**RE: ABP-318758-23 – WESTGATE 2040, DROGHEDA, CO. LOUTH – PUBLIC REALM REGENERATION WORKS**

This letter has been prepared by Turley Planning Ireland Ltd and members of the wider Westgate Design Team, on behalf of Louth County Council, in response to An Bord Pleanála's (hereafter 'the Board') recent request to make submissions or observations in relation to the 11 no. submissions received by the Board during the public consultation stage of the Westgate 2040 planning application process.

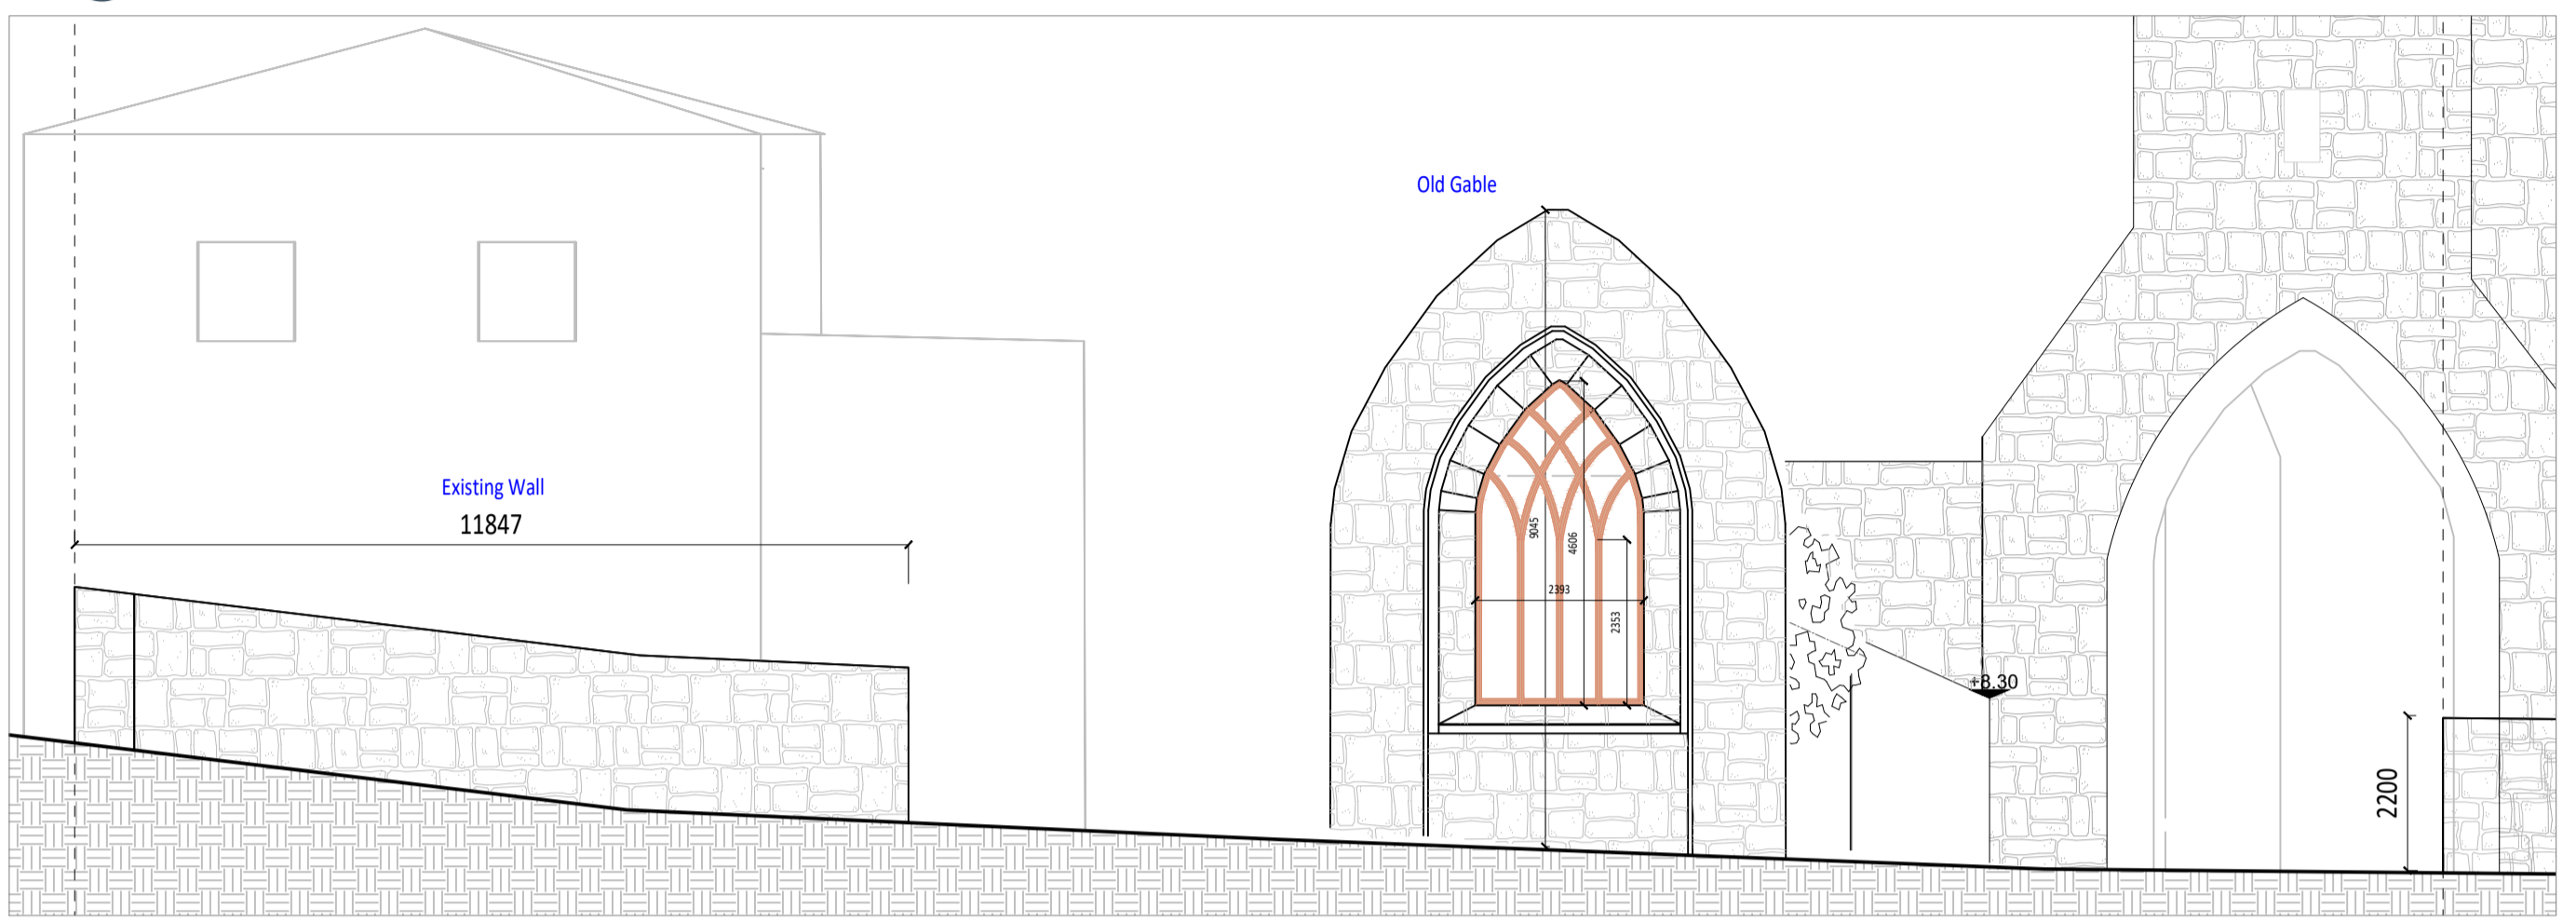
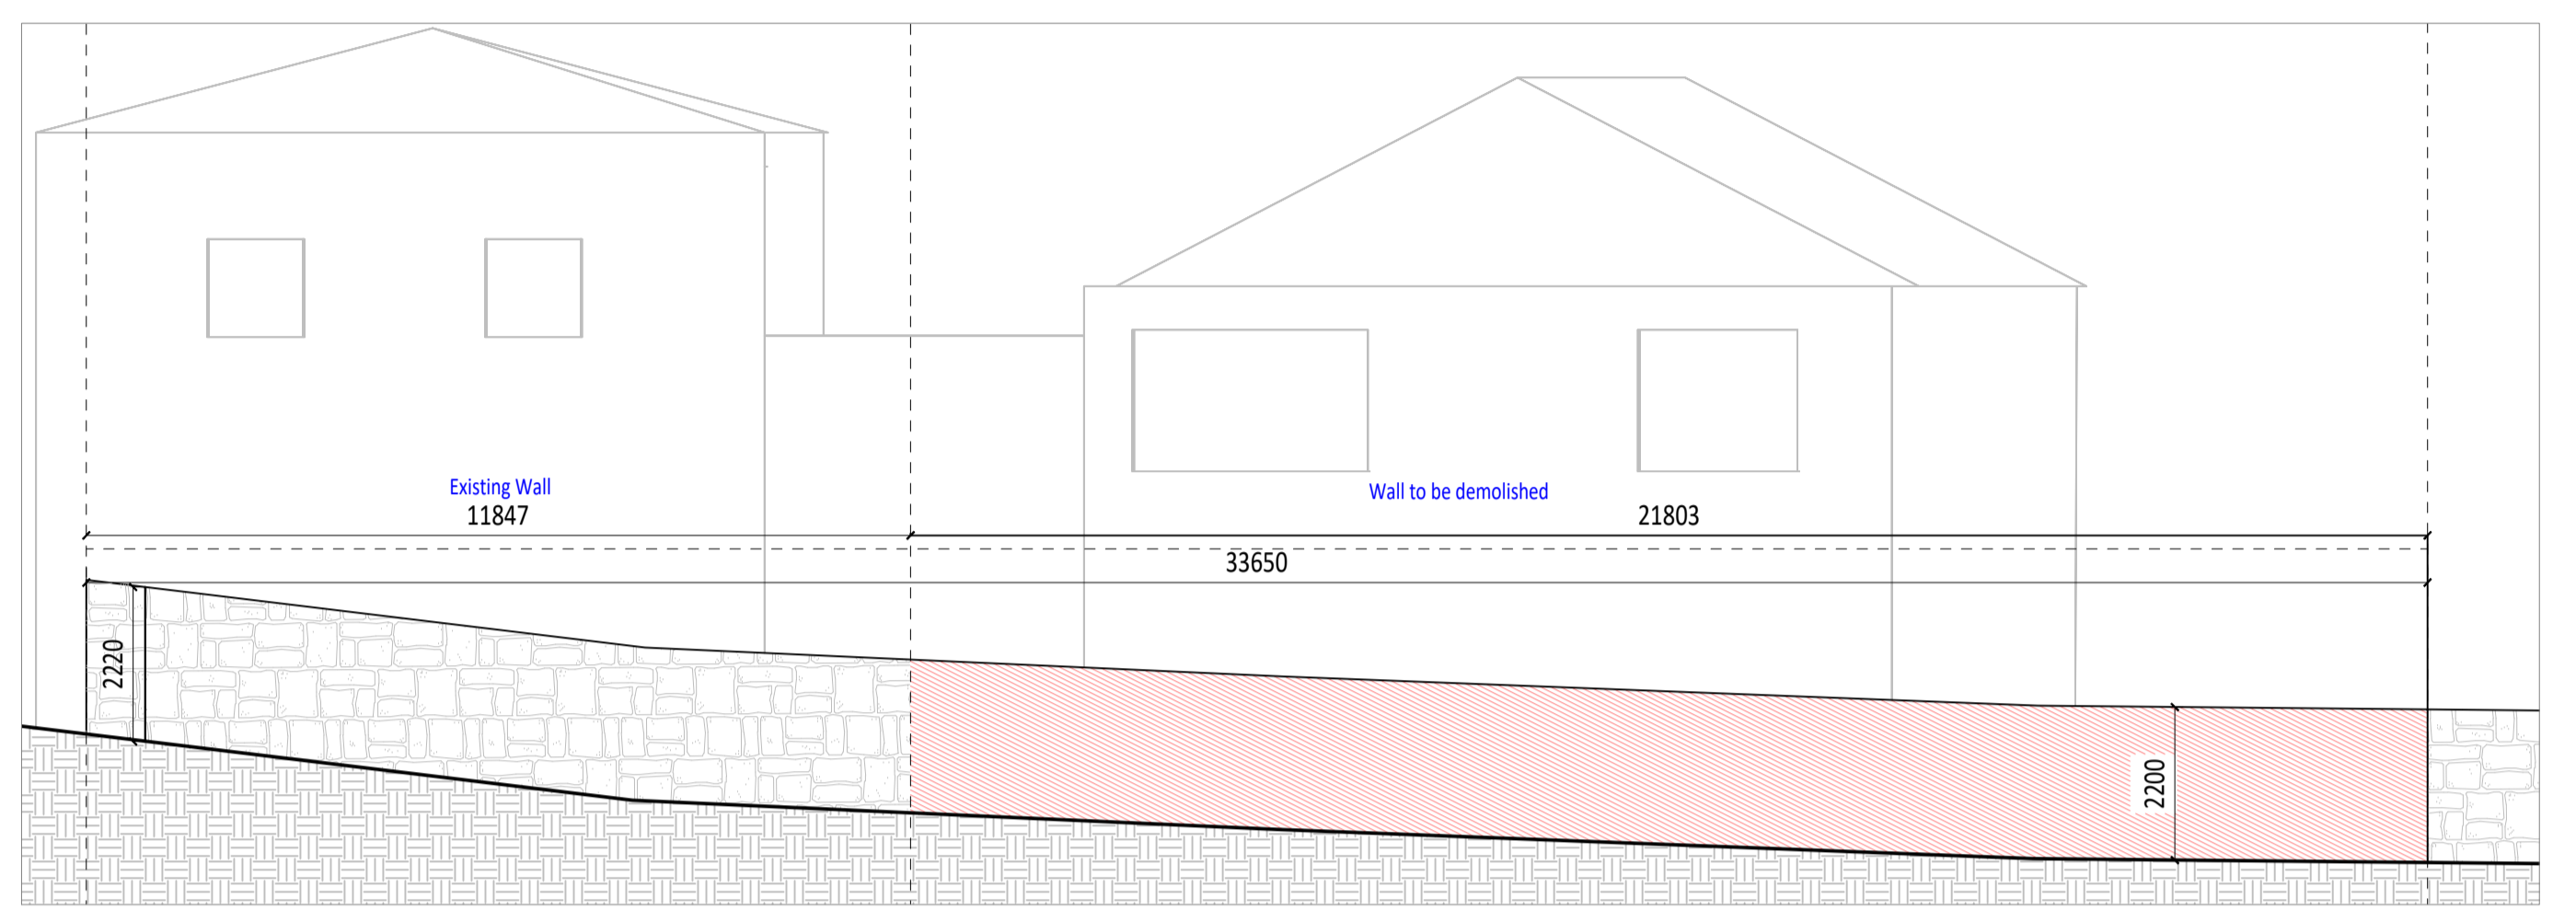
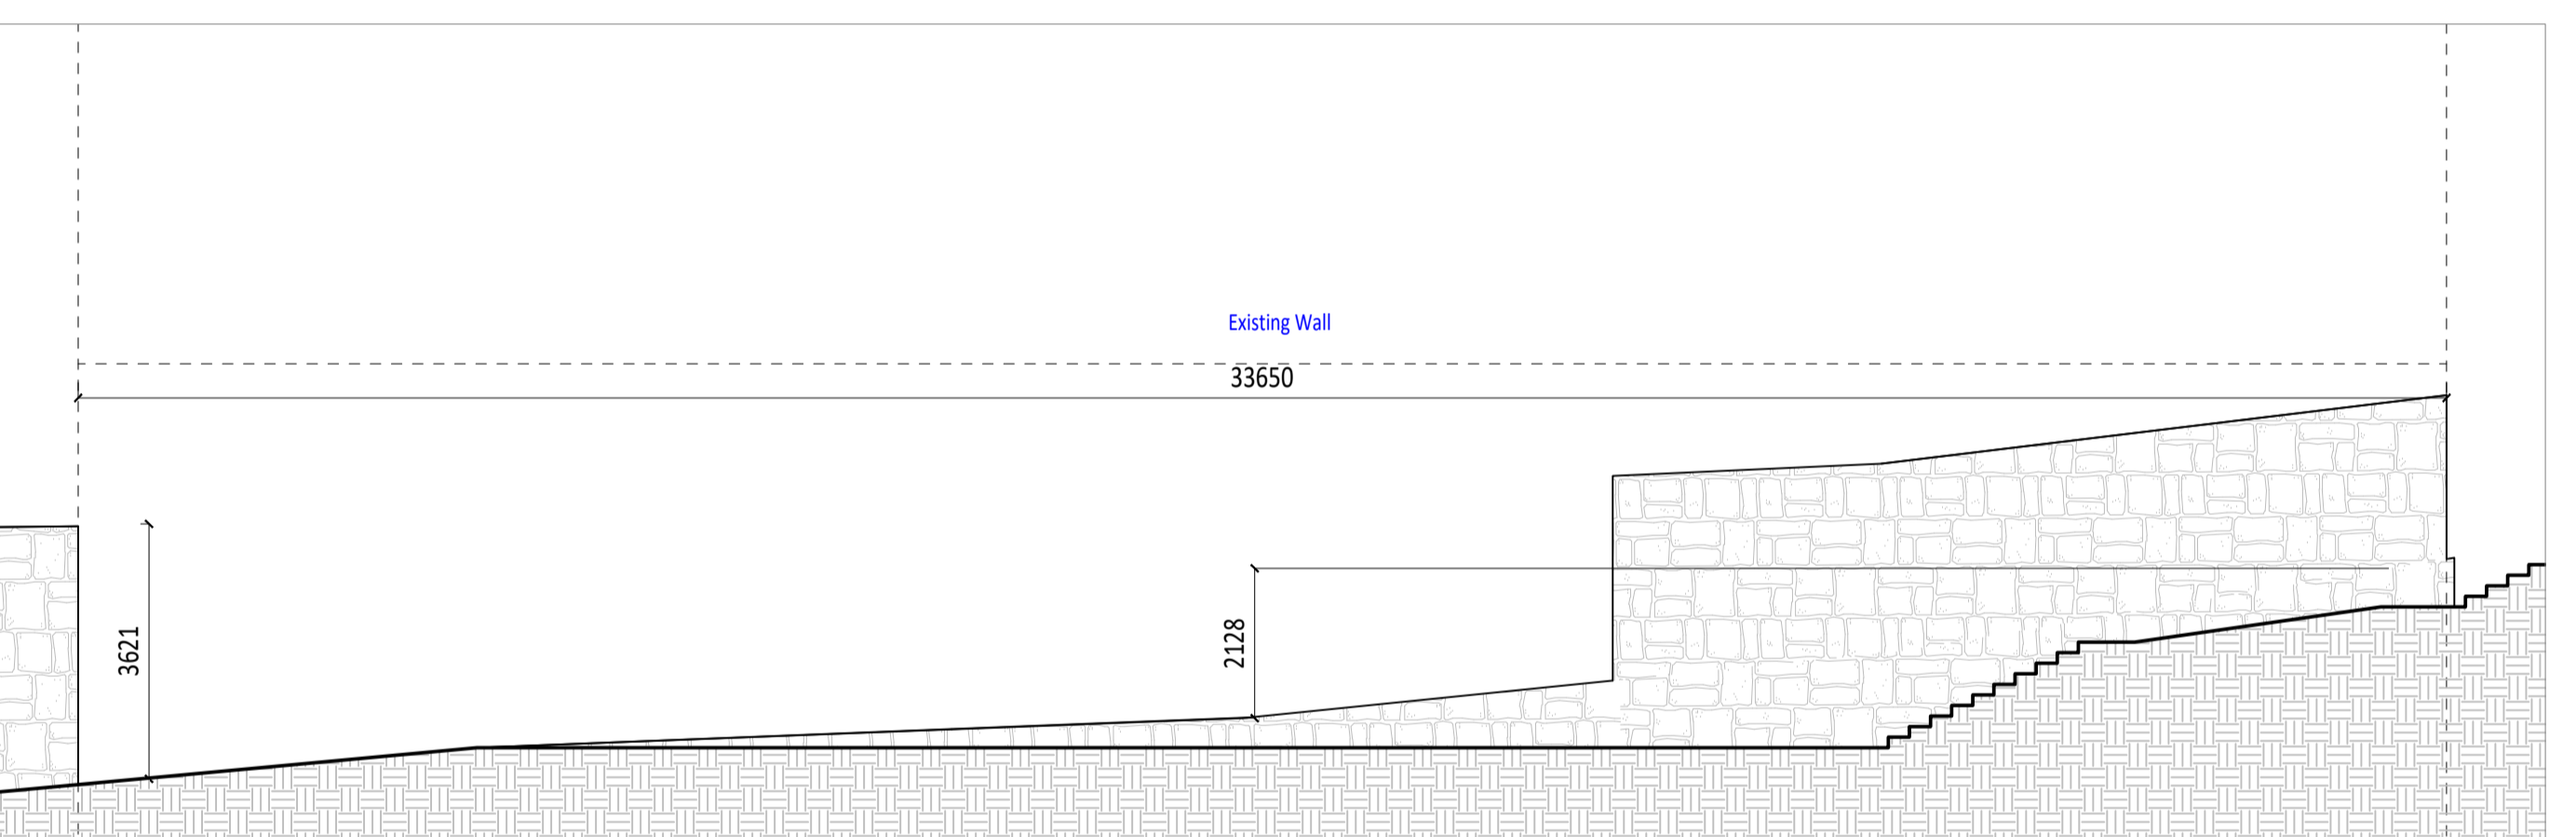
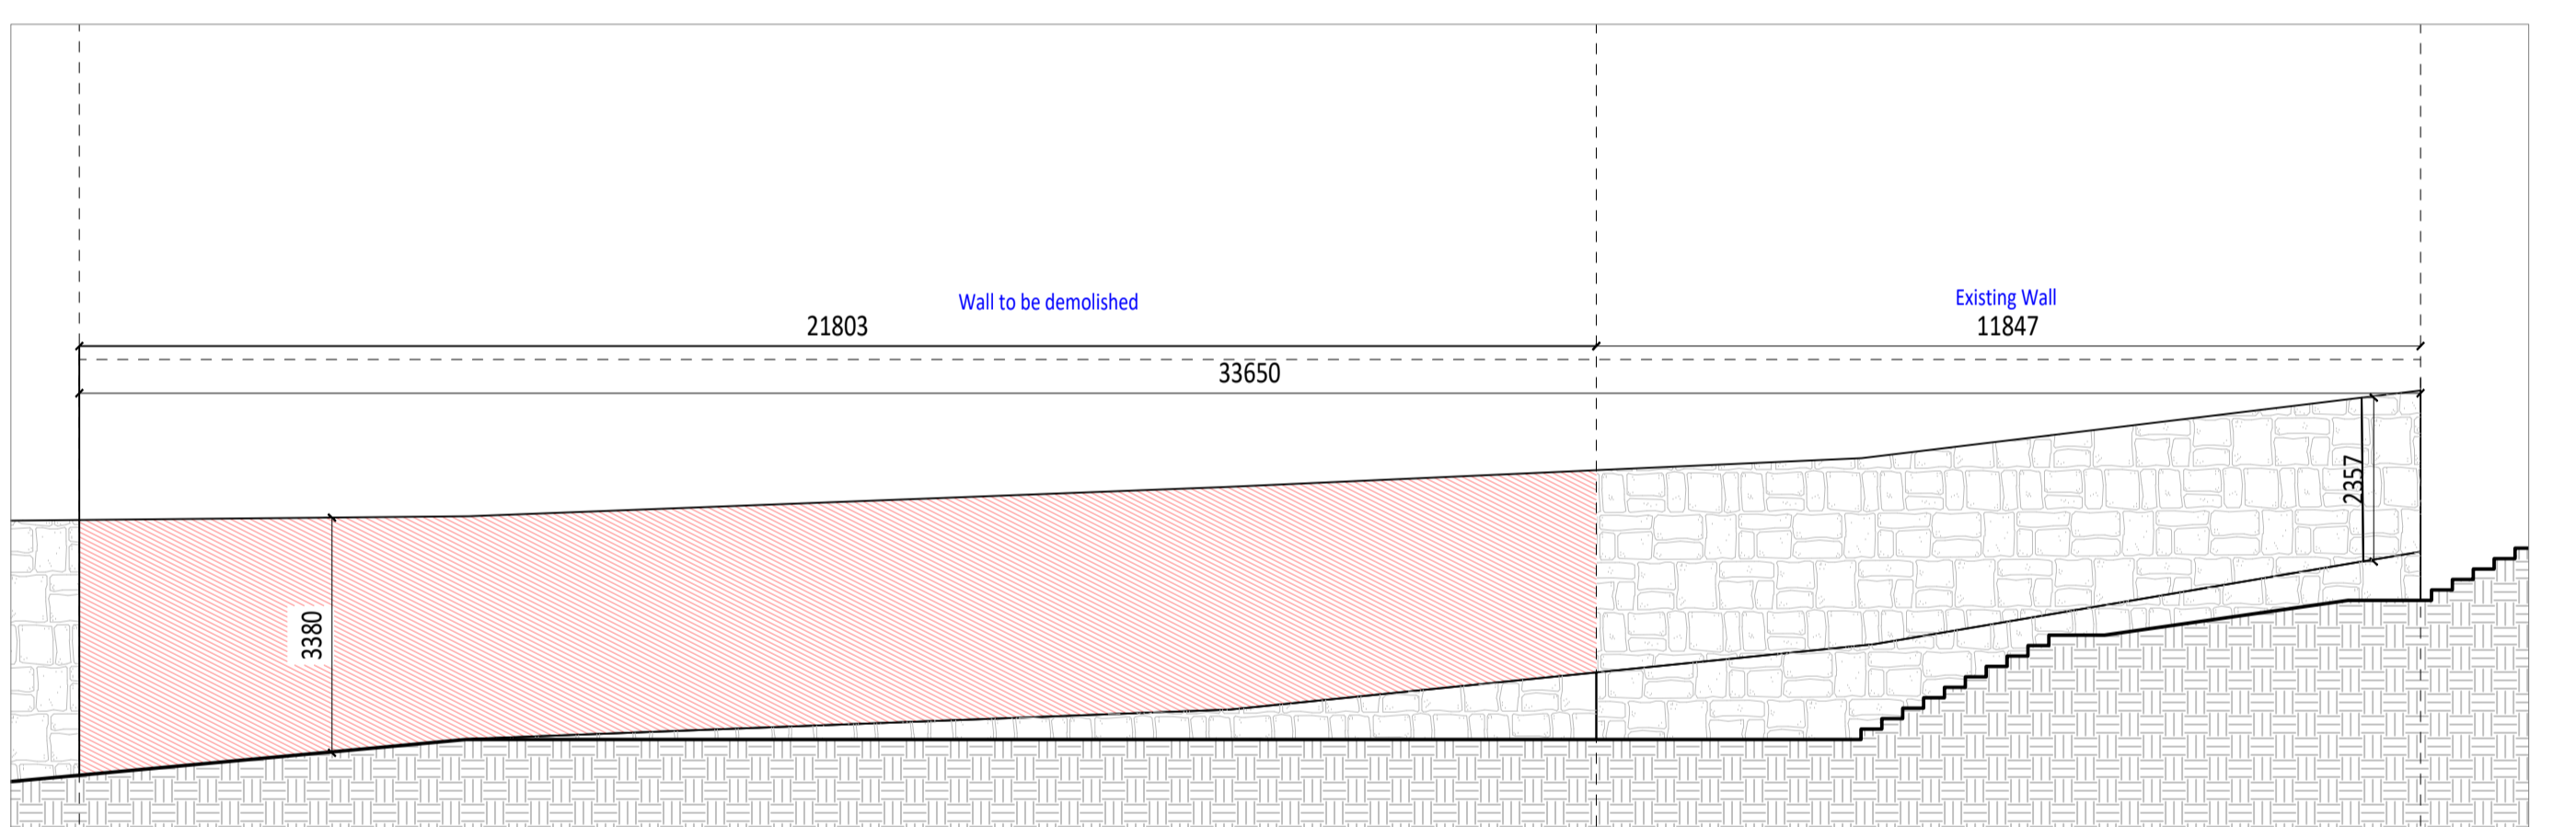
### **Demolition of Wall between Father Connolly Way and Old Abbey Lane**

The demolition of the section of wall located between Father Connolly Way and Old Abbey Lane has been assessed in the EIAR and no adverse effects with respect to cultural heritage, archaeology or architectural heritage have been identified as a result of the proposed demolition.

The proposed demolition seeks to create a new direct physical and visual link to/from West Street/Father Connolly Way/Old Abbey Lane to provide enhanced connectivity between these areas and invite people from West Street down to the new public realm areas and interventions within Old Abbey Lane and onwards towards the riverfront area. The proposed demolition will also help to create a stronger context connecting the Abbey structure to its surroundings streets and laneways and alleviate concerns surrounding anti-social town centre spaces.
